**Subject:** George Hotel - HE Consultation Response

Further to our e-mails and ref. HE's structural concerns (copy attached) we respond to the further comment contained in the HE report as follows:

- 02 Second Floor Level**  
**Category 1 - New Walls**
- 2-1-1 New wall infill into existing door opening.
  - 2-1-2 New wall infill into existing door opening.

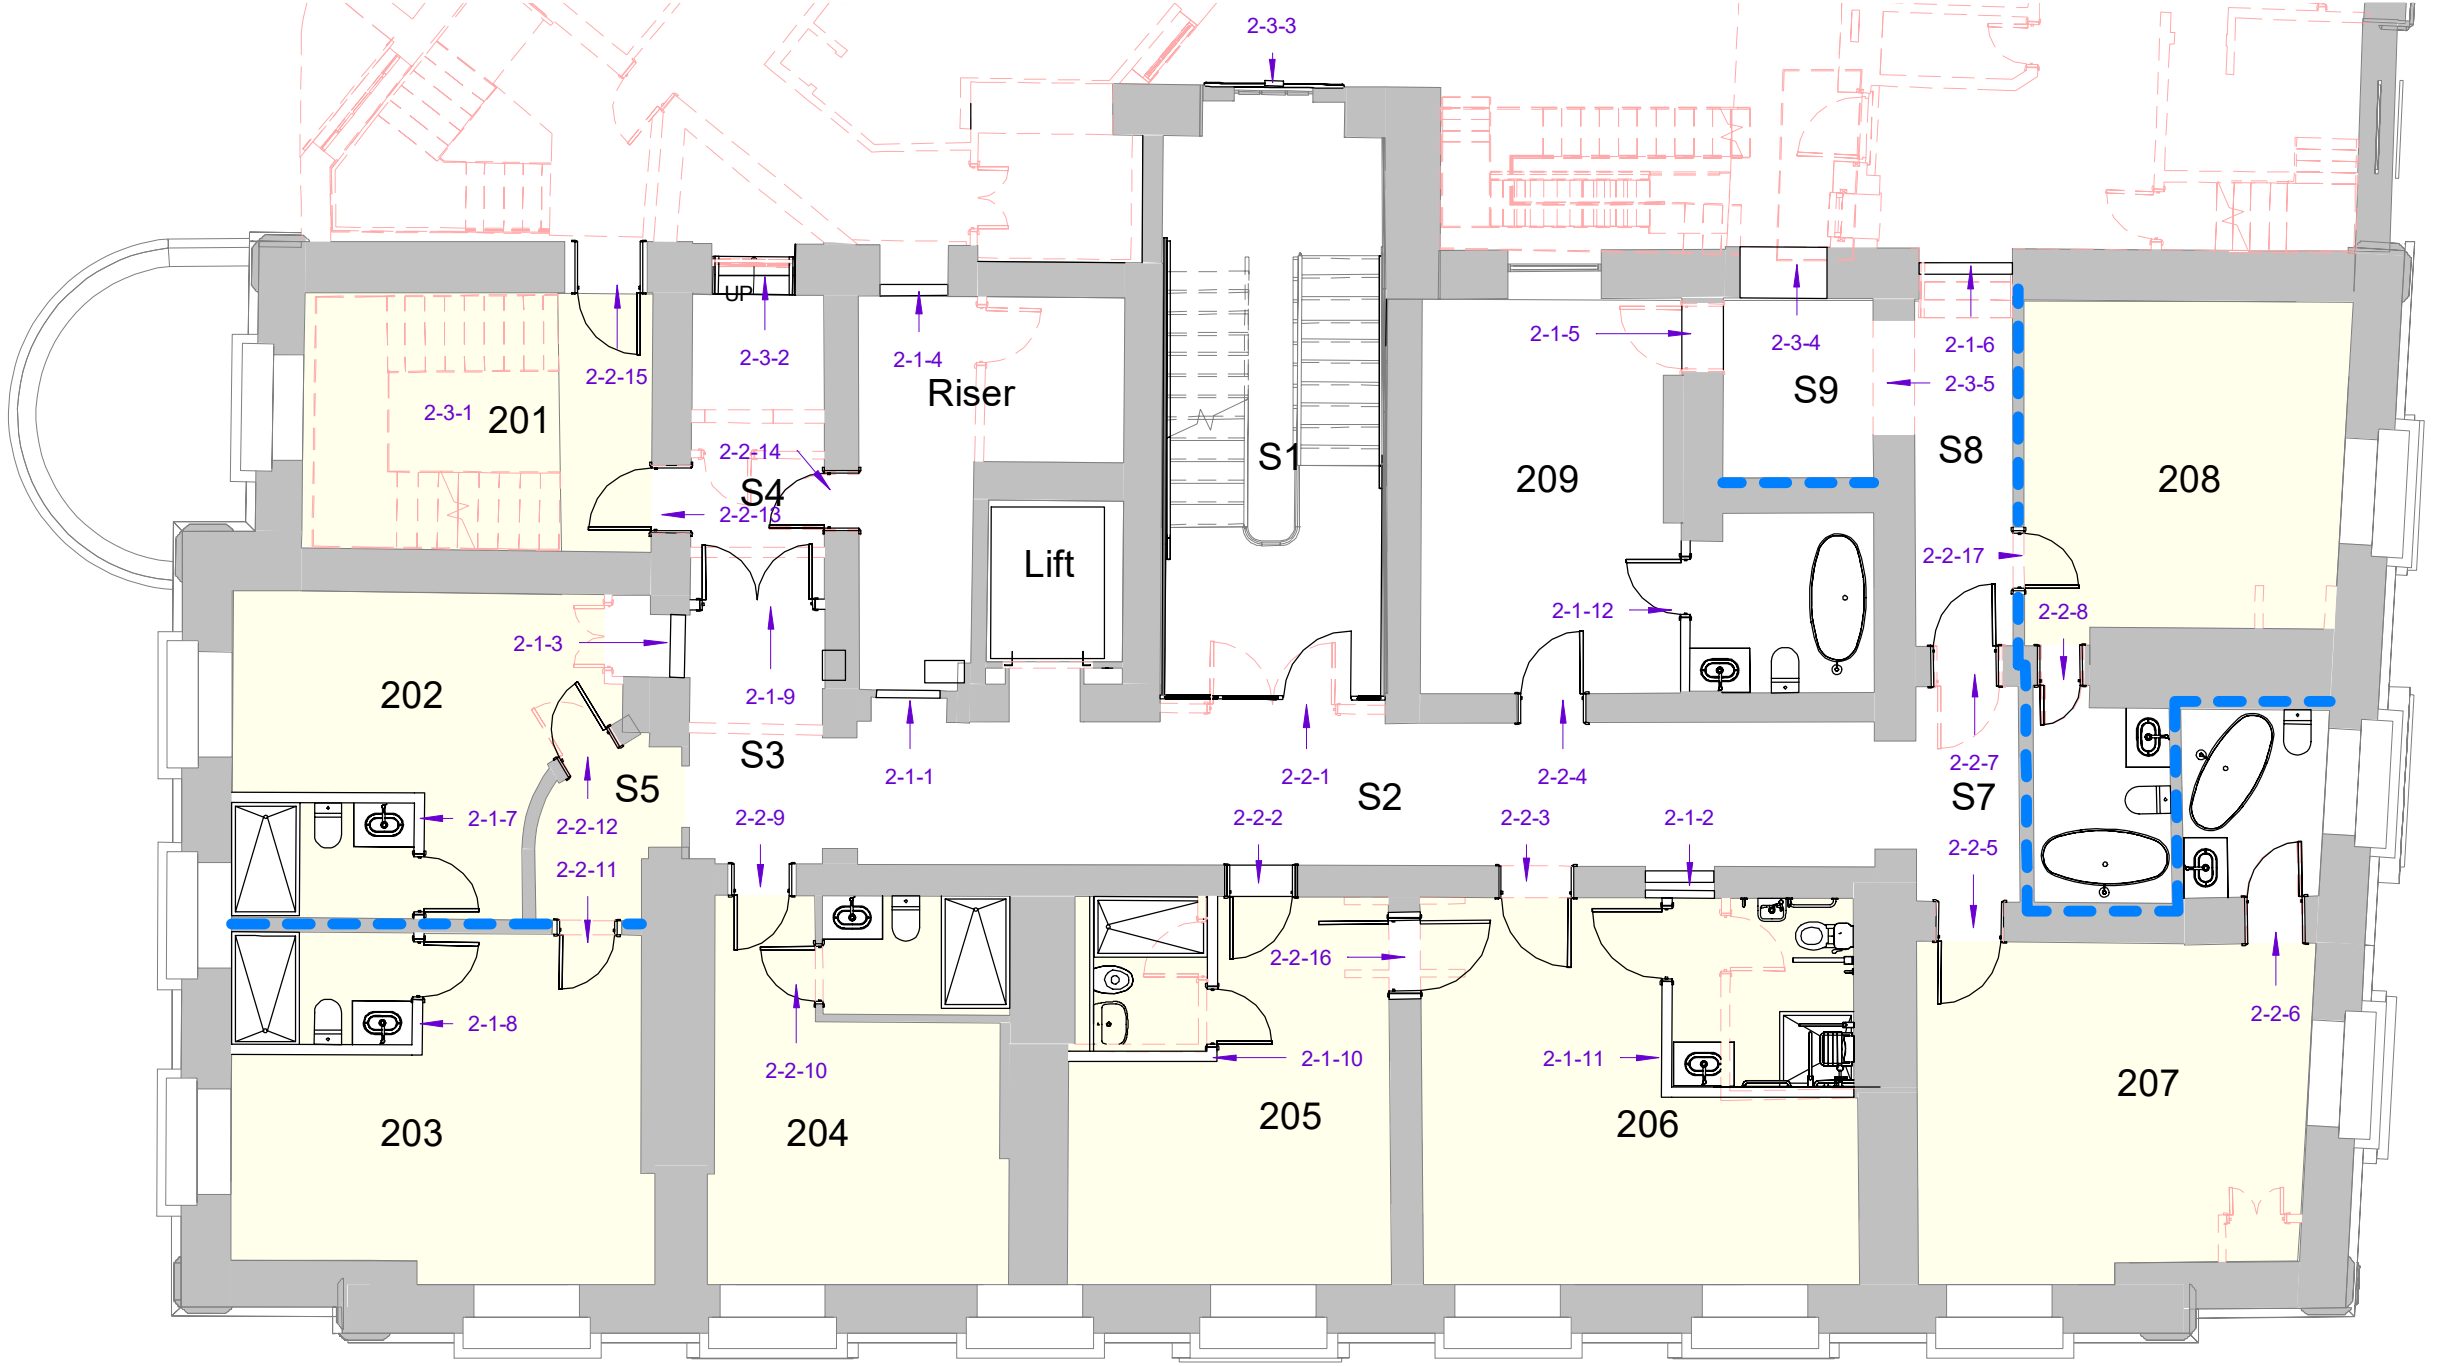
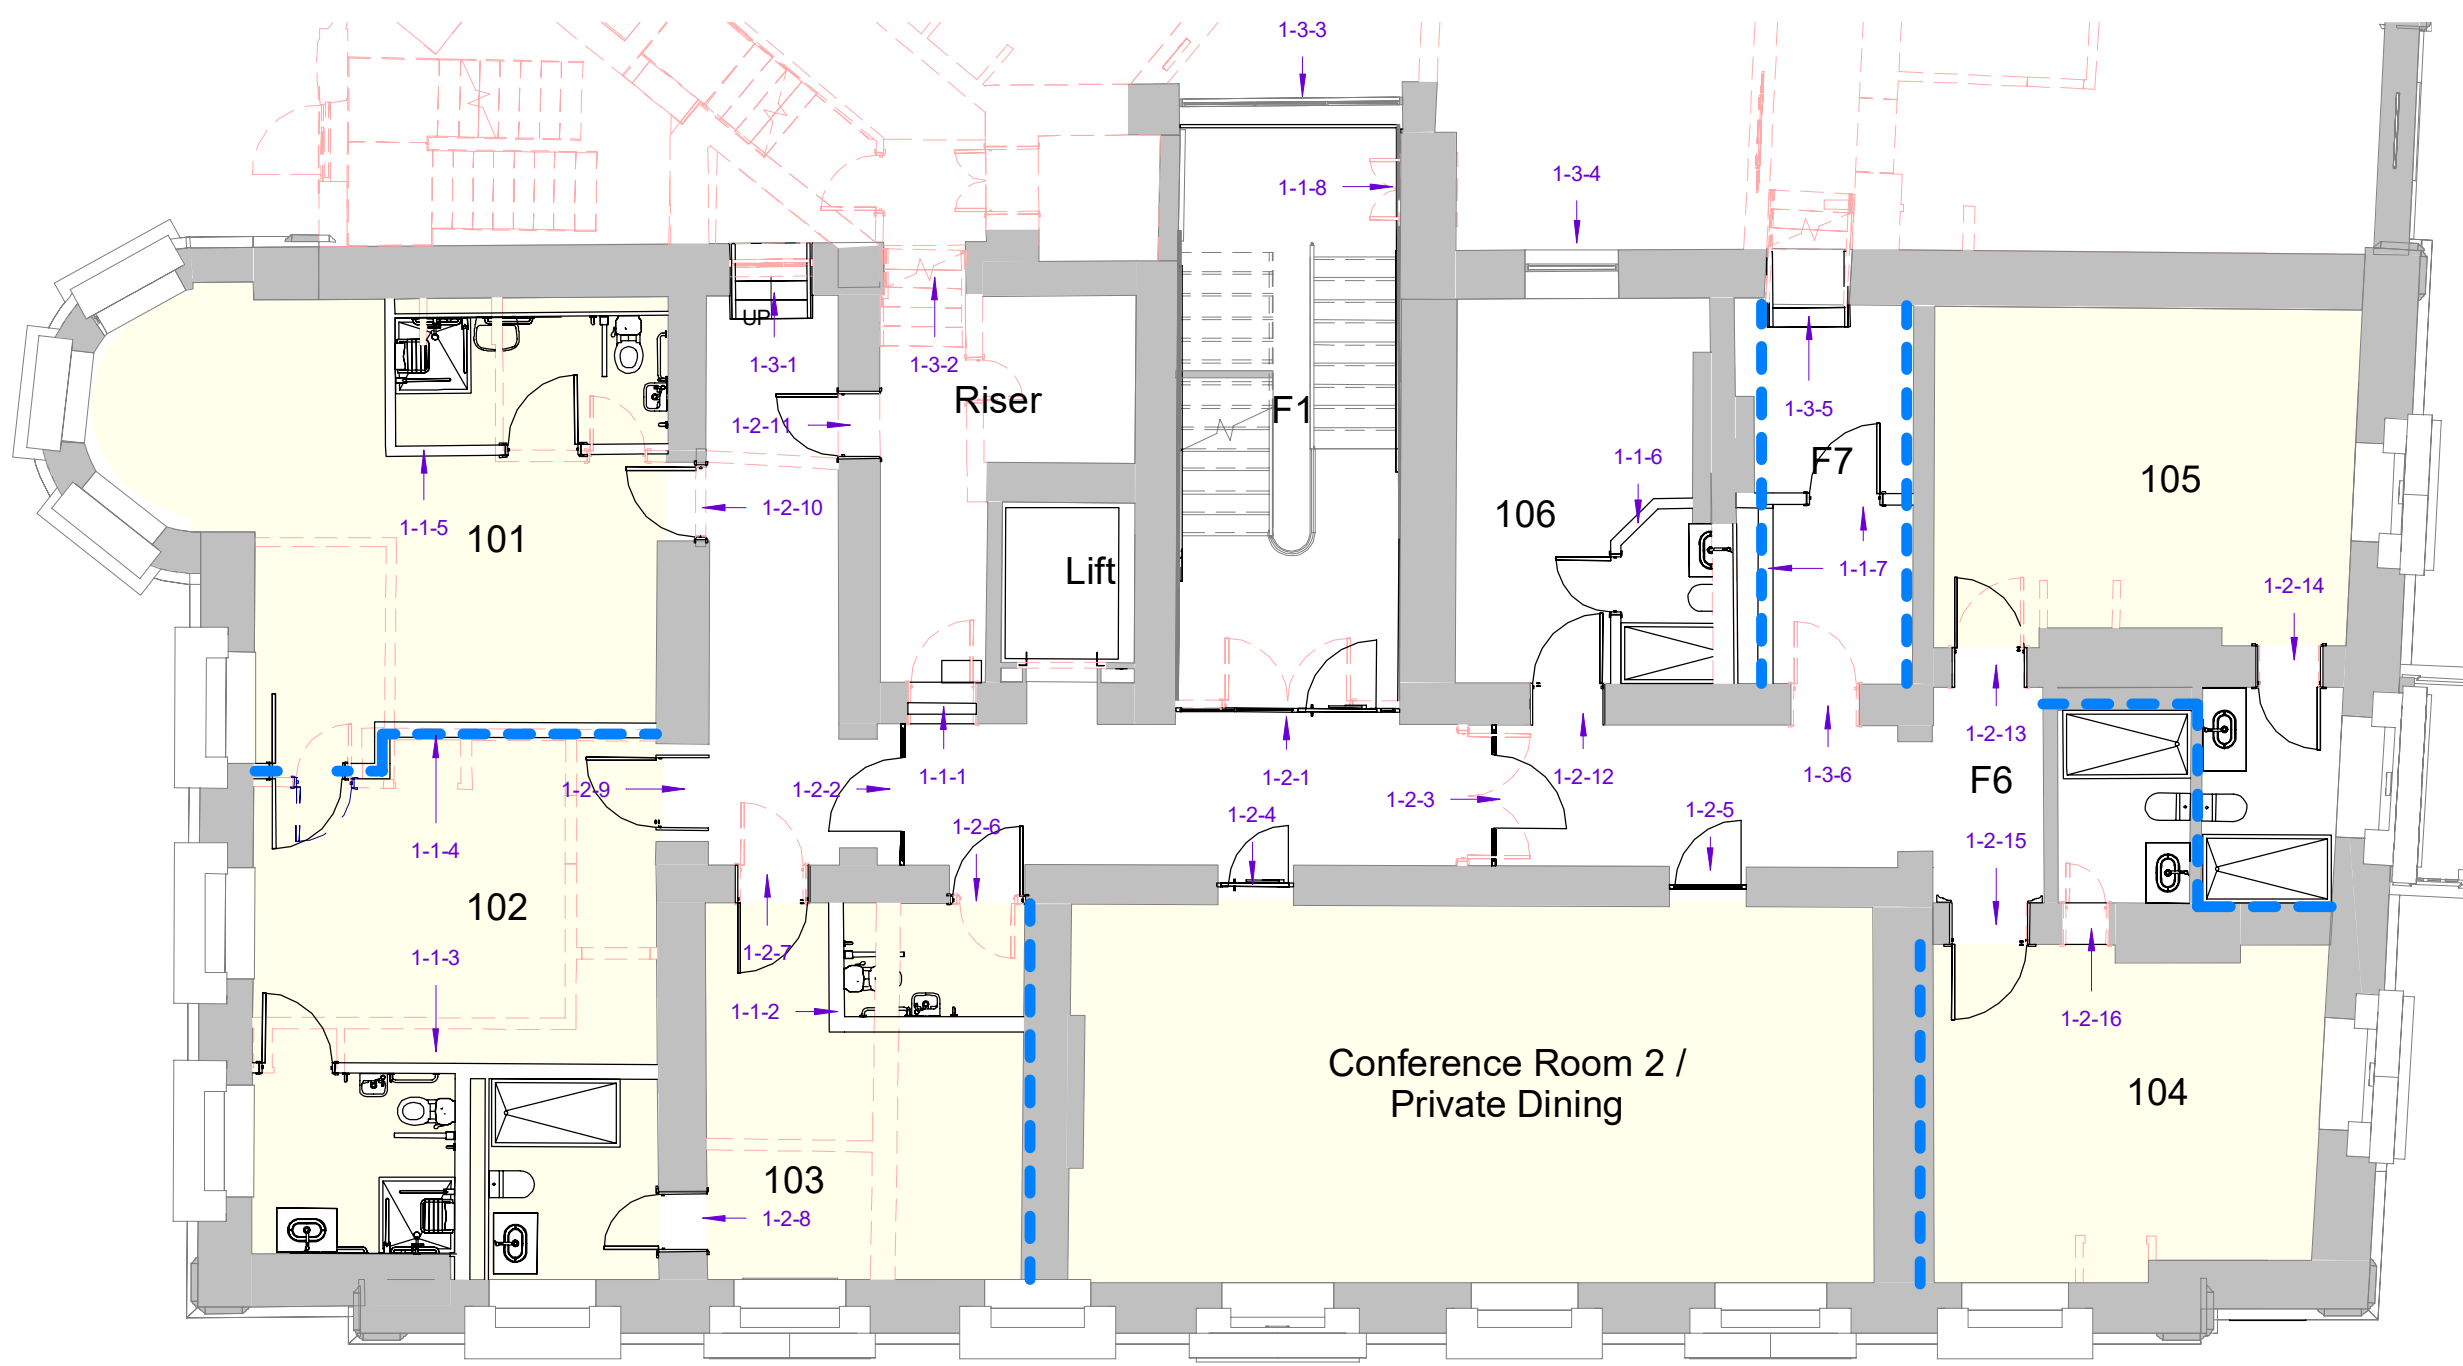
- Note timeframes and whether this is necessary. We suggest not as the viability assessment was carried out by a relevant professional company
- 7. "we are not satisfied that there is a convincing justification for the removal of *all* the floor structures in block A" doc L01555367

- Corridor floors and some room floors are *not* being replaced. See drawings.
  - Please see attached commentary by separate cover.
- 8. "The remaining less than substantial harm should be weighed against the public benefits of the scheme" doc L01555367
